Item No. **Report of the Head of Planning, Transportation and Regeneration**

Address 360 BATH ROAD HARMONDSWORTH

Development: Single storey front/side/rear extension

LBH Ref Nos: **13135/APP/2019/1336**

HPA - GF front / rear & side extensions

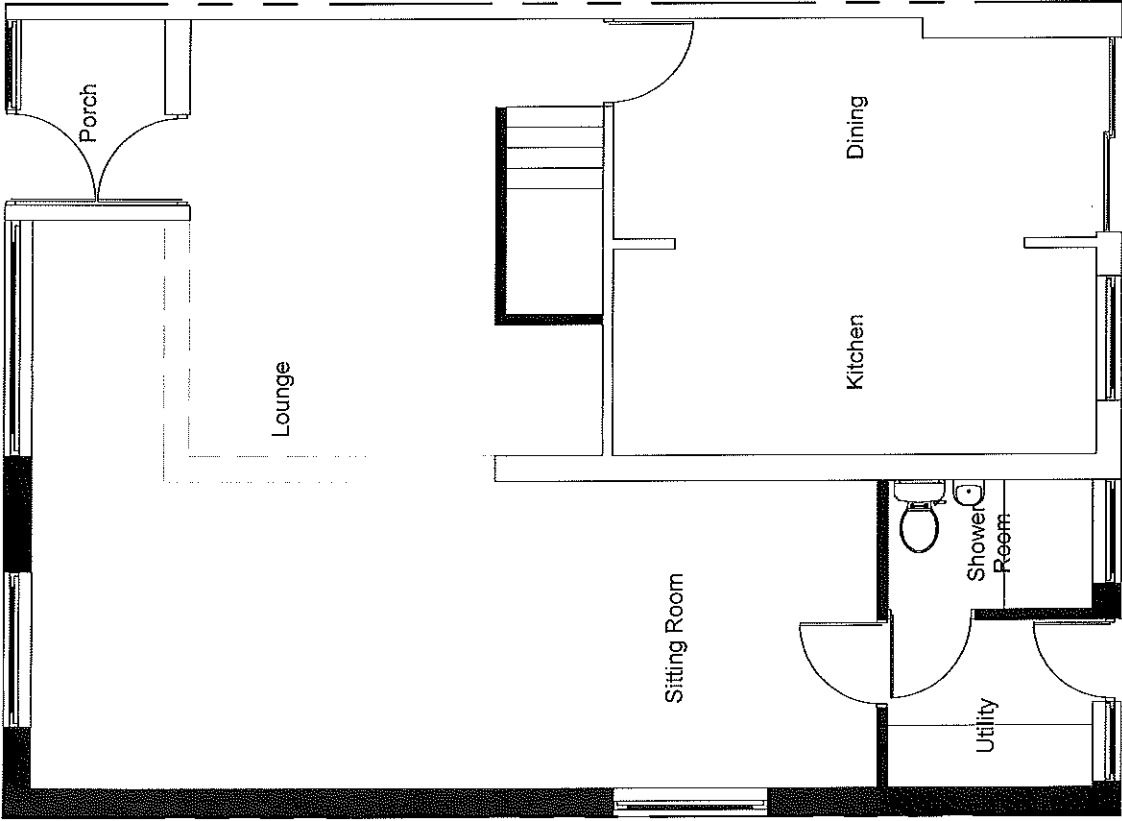
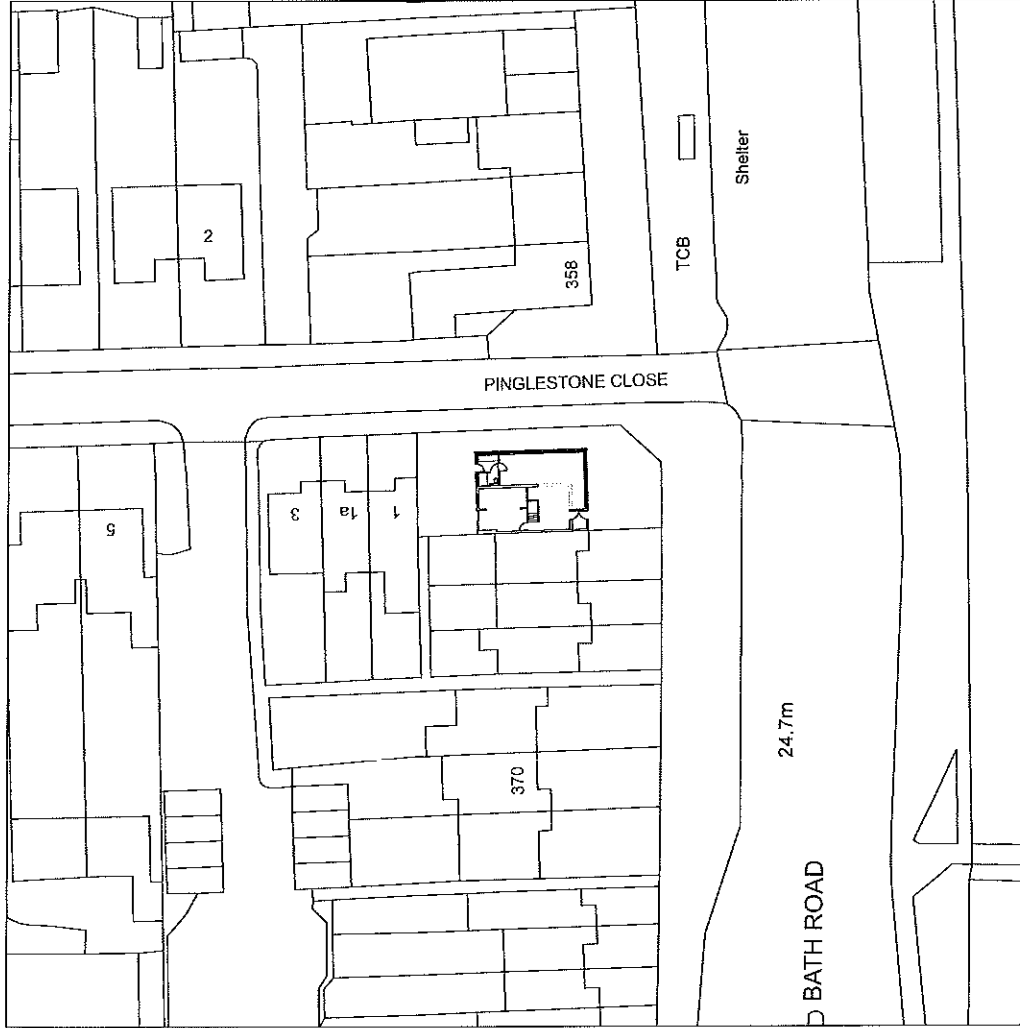
The proposed single storey side extension would result in the infilling of a substantial part of this space at and would result in the loss of this prominent open space feature to the detriment of the visual amenity of the Bath Road and Pinglestone Close street scenes and the wider area. The proposed development would, by virtue of its excessive scale and bulk, and its breach of the return building line, represent an over-development of the site to the detriment of the character and the visual amenities of the surrounding area, and to

The proposal also includes a front extension. The proposed side extension would be flush with the front porch, rather than the front wall of the main dwelling. It is considered that the scale of this extension would therefore change the face to this dwelling and terrace and would fail to appear as a subordinate addition. The proposed extension, by virtue of its size, scale, bulk and forward projection at ground floor level would result in an incongruous addition which would be detrimental to the architectural composition of the existing dwelling and terrace and would harm the character and appearance of the wider area. The proposal would therefore be contrary to policies BE13, BE15, BE19 and BE22 of the Hillingdon Local Plan: Part Two - Saved UDP Policies (September 2007) and the Council's adopted Supplementary Planning Document HDAS: Residential Extensions.

The proposed extension by reason of its size, scale, bulk, depth, width, proximity to the side boundary and projection forward of the return building line along Pinglestone Close, in this open prominent position, would result in the closing of an important gap characteristic to the area, resulting in a cramped appearance. The proposal would therefore represent an overdevelopment of the site to the detriment of the visual amenities of the street scene and the character and appearance of the surrounding area. The proposed development is therefore contrary to Policy BE1 of the Hillingdon Local Plan: Part One - Strategic Policies (November 2012), Policies BE13, BE15 and BE19 of

The proposed front extension, by virtue of its size, scale, bulk and forward projection at ground floor level would result in an incongruous addition which would be detrimental to the architectural composition of the original dwelling, to the character, appearance and symmetry of the small terrace of houses of which it forms a part and to the visual amenities of the street scene and the surrounding area. Therefore the proposal would be contrary to Policy BE1 of the Hillingdon Local Plan: Part One - Strategic Policies (November 2012), Policies BE13, BE15 and BE19 of the Hillingdon Local Plan: Part Two - Unitary Development Plan Saved Policies (November 2012) and the adopted Supplementary Planning Document HDAS: Residential Extensions.
